Ref: Vanguard Printing File No. J14/D21

I have reviewed your drainage plan dated 4/22/97 for a building permit and submit the following comments:

RE: REVISED DRAINAGE PLAN FOR VANGUARD PRINTING (J14-D21) REVISION
DATED 5/13/97

DRIVEPADS

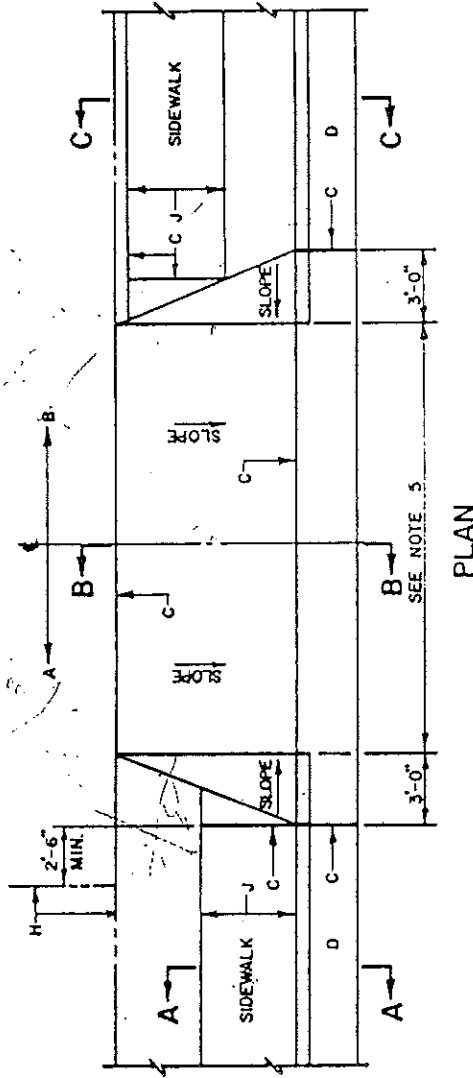
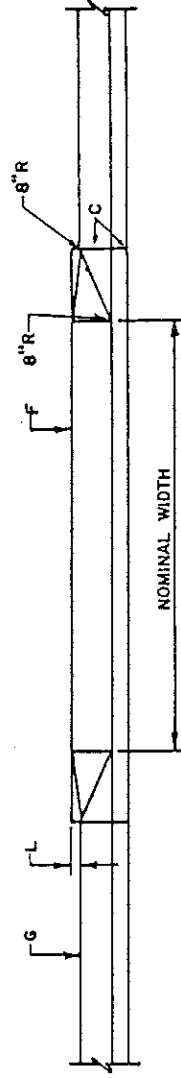
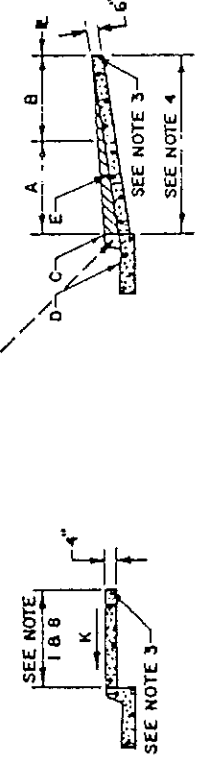
1. Will the increase flows to the alley be contained within the alley? Please address this question on the drainage plan.
2. Please provide the proposed and existing M.S.L. grades for the new curb and gutter and drivepads. Note: the finish grade at the property line must be 0.33' above top of curb per the City of Albuquerque Standard Specifications Drawings.
